Our Ref: EN010106

Date: 10 March 2023

Application by Sunnica Ltd for an Order Granting Development Consent for the Sunnica Energy Farm Project

Request for further information

Drawing Number 60589004_ES_PS_013	Rev 0
---	-----------------

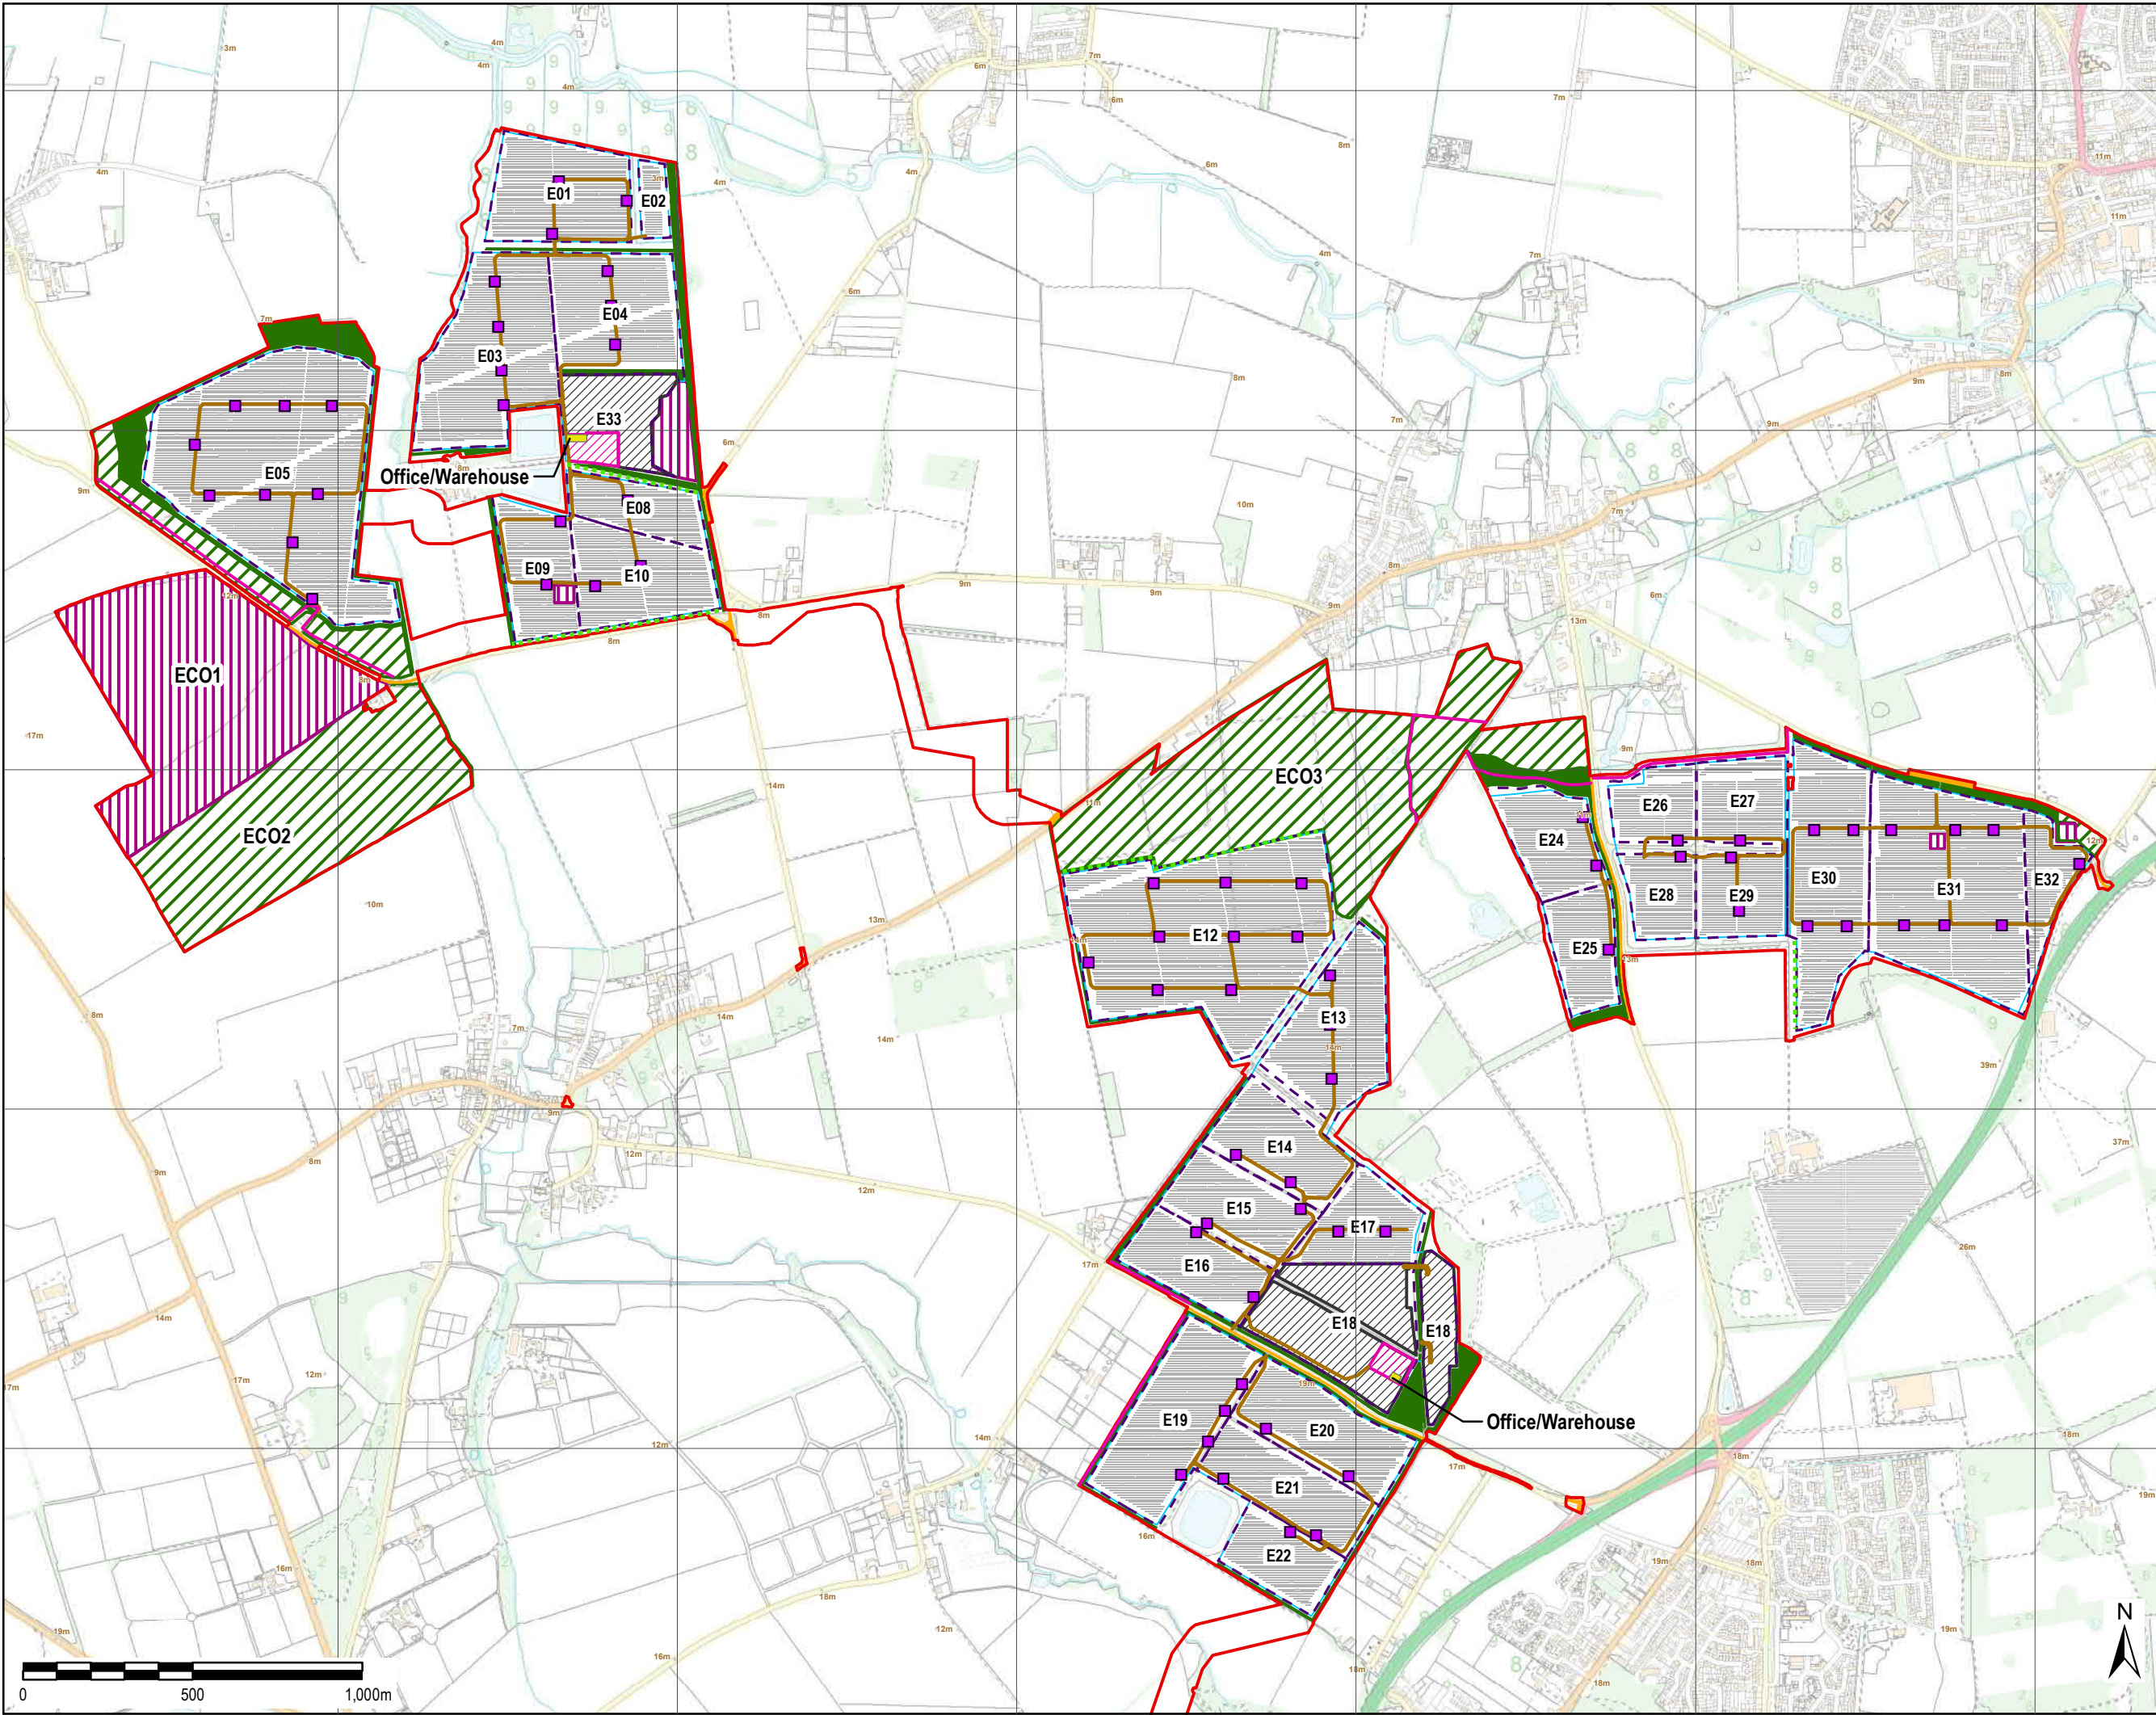
- 1 Would the Applicant, with reference to parcels E05, E12, E13 and W03-W12, and works plans [REP6-006] confirm that in the event no solar panels or other above ground infrastructure may be provided in the specified land parcels in Table 1 of [REP-073] there would be no need for any electrical cables as authorised by Work No. 1 in those parcels?

- 3 The ExA notes that the Applicant, in its Deadline 7 Submission - Applicant's response to SCC's proposed amendments to Schedule 1 [REP7-064], is concerned that SCC's drafting fails to account for their own "half-way house" position in which restrictions on the developable areas of E12, E13 and E05 were proposed, despite its recognition that its concerns could in large part be

addressed by restrictions on the developable area. The Applicant is therefore invited to provide alternative amendments to its dDCO to address its concerns if it wishes the Secretary of State to consider the “half-way house” position as a viable option.

- 4 Further, it would appear to the ExA that if the Applicant wishes the Secretary of State to consider granting a reduced DCO with the parcels deleted as proposed by the local authorities, the Applicant should identify and provide details of a cable corridor within the removed fields on the Land and Crown Land Plans and Works Plans, and propose any consequential amendments to Schedule 8 of the dDCO.

- 7 With regard to Work No.10 it would appear to the ExA that if there were to be no panels in parcels E12 and E13, parcel EC03 would not be required to be laid out for stone curlew offsetting. Does the Applicant agree and if not please explain why not?

Drawing Number 60589004_ES_PS_014	Rev 0
--------------------------------------	----------

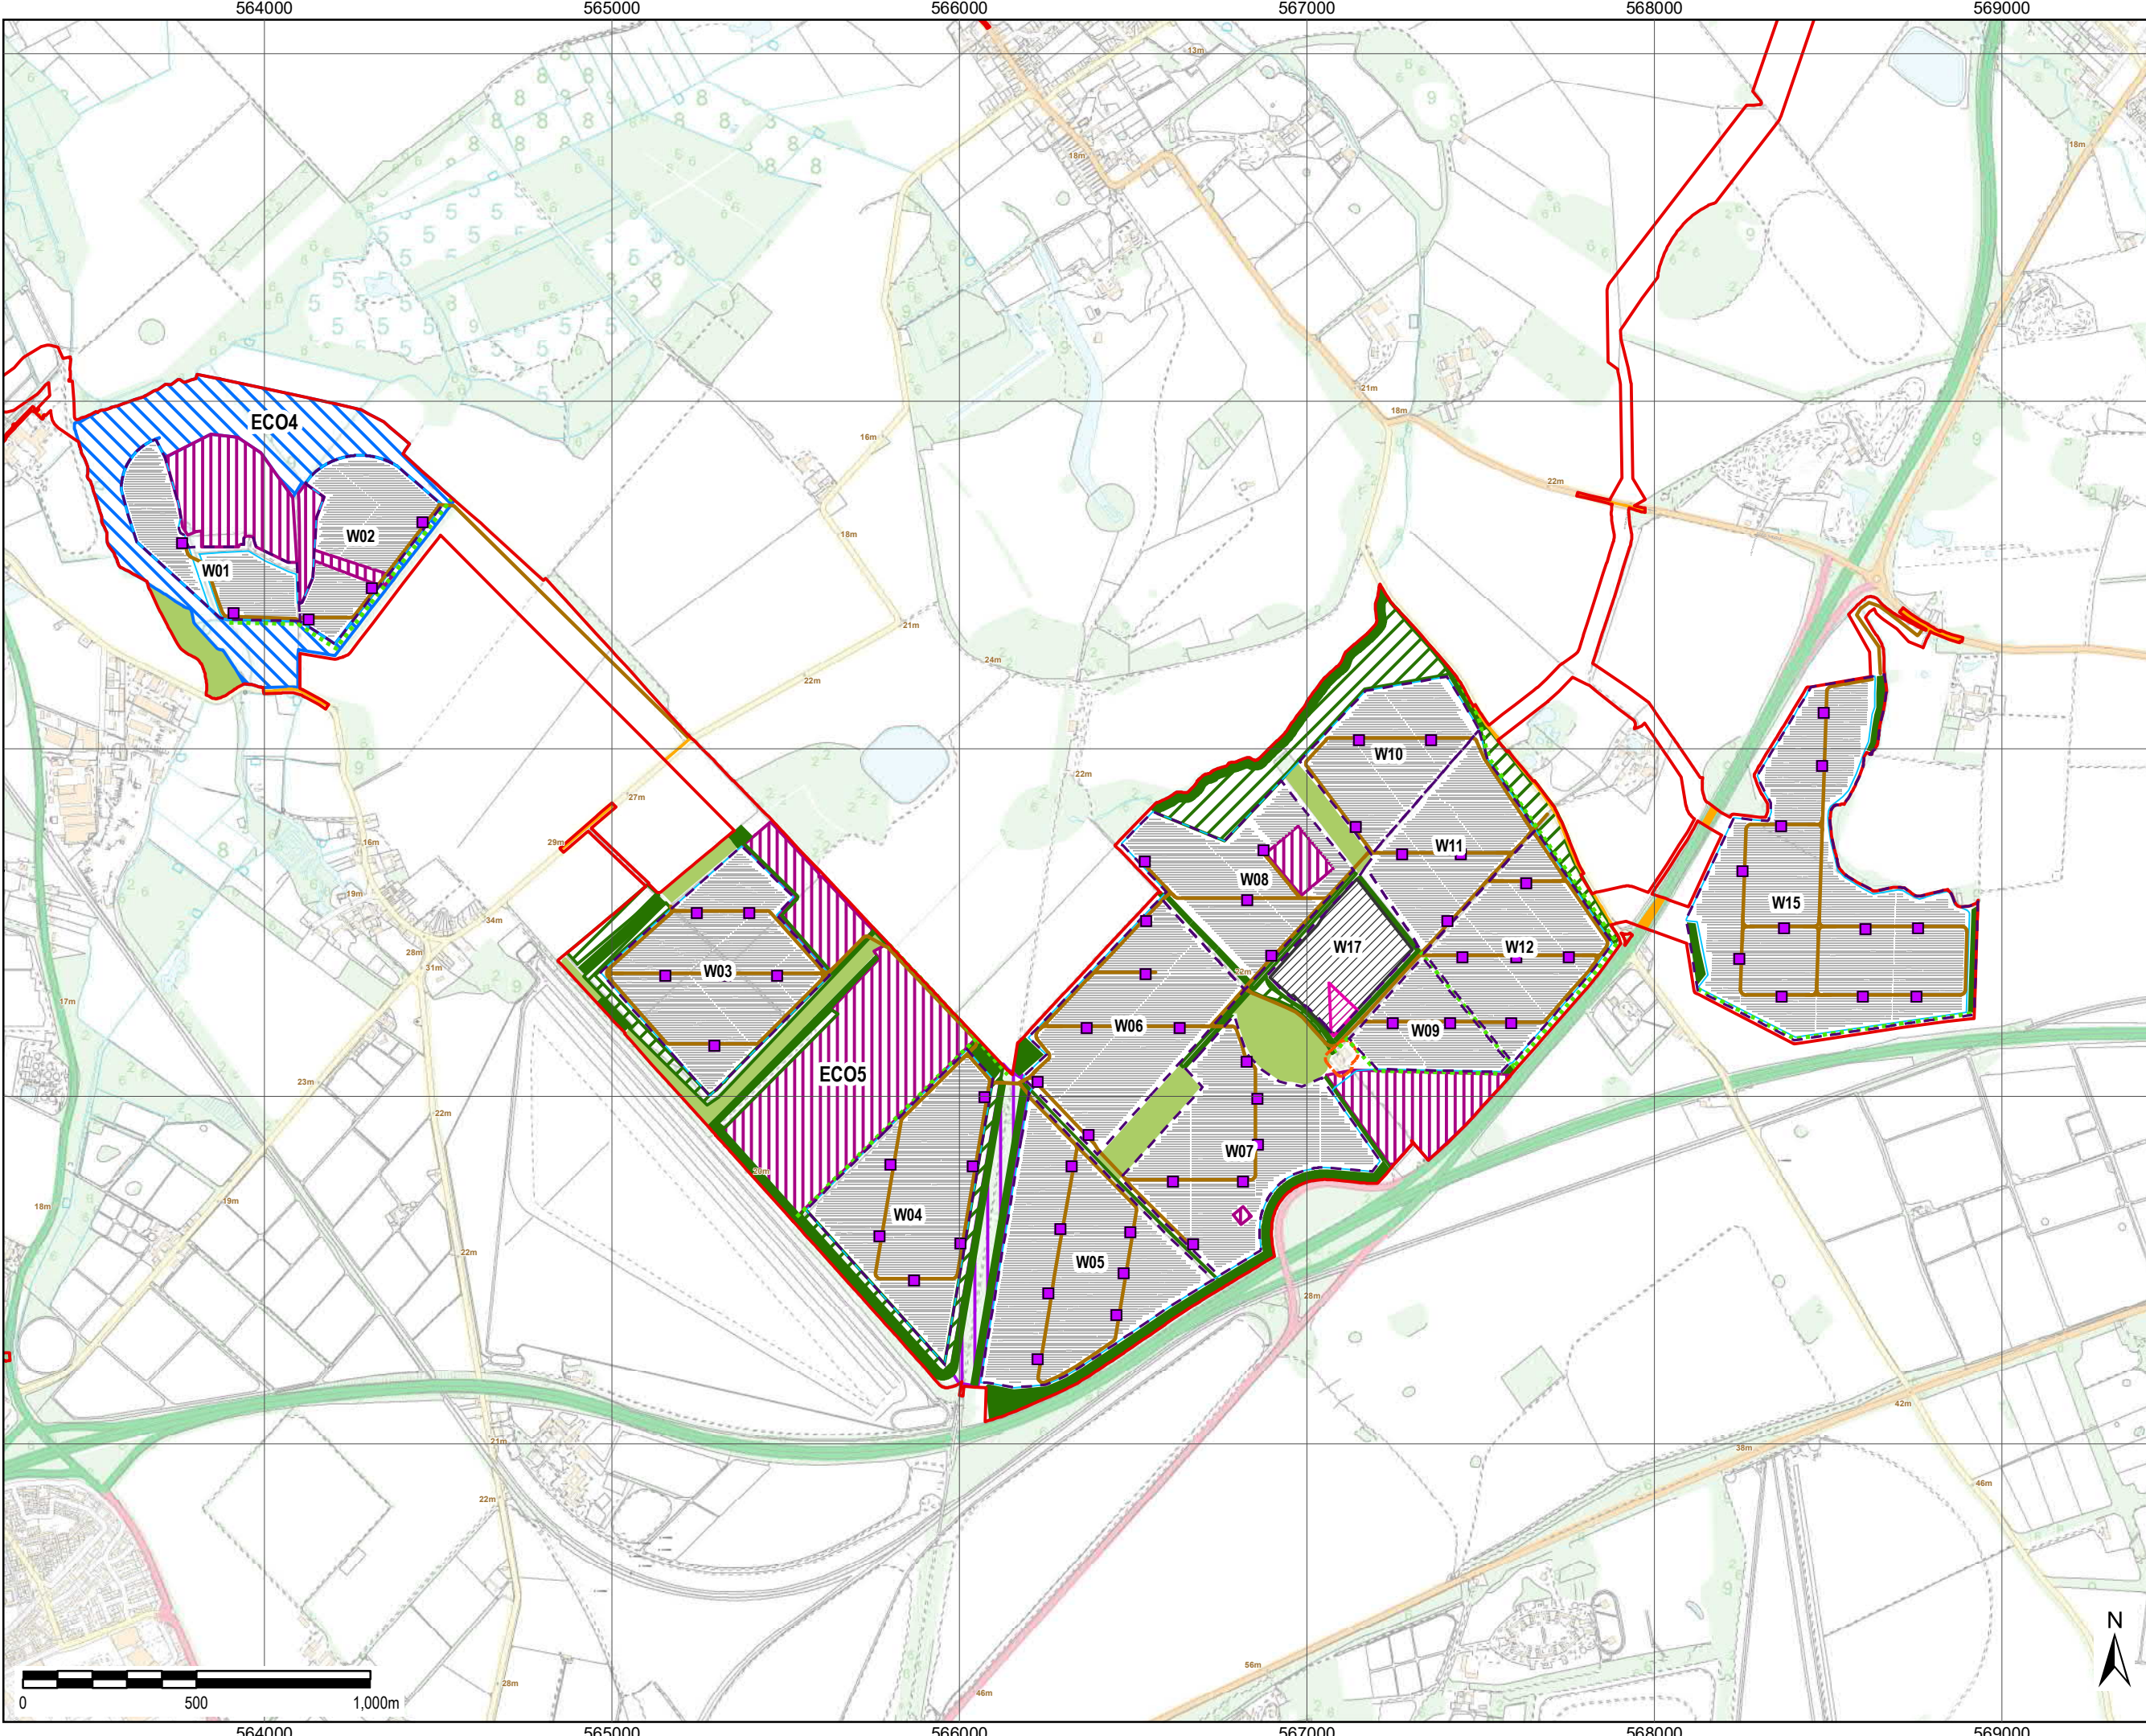
- 5 With regard to Work No. 2C (the BESS for Sunnica West A), it would appear to the ExA that there would be no need for this work if solar panels and other above ground infrastructure were to be excluded from parcels W03-W12. In that eventuality please would the Applicant confirm the position.
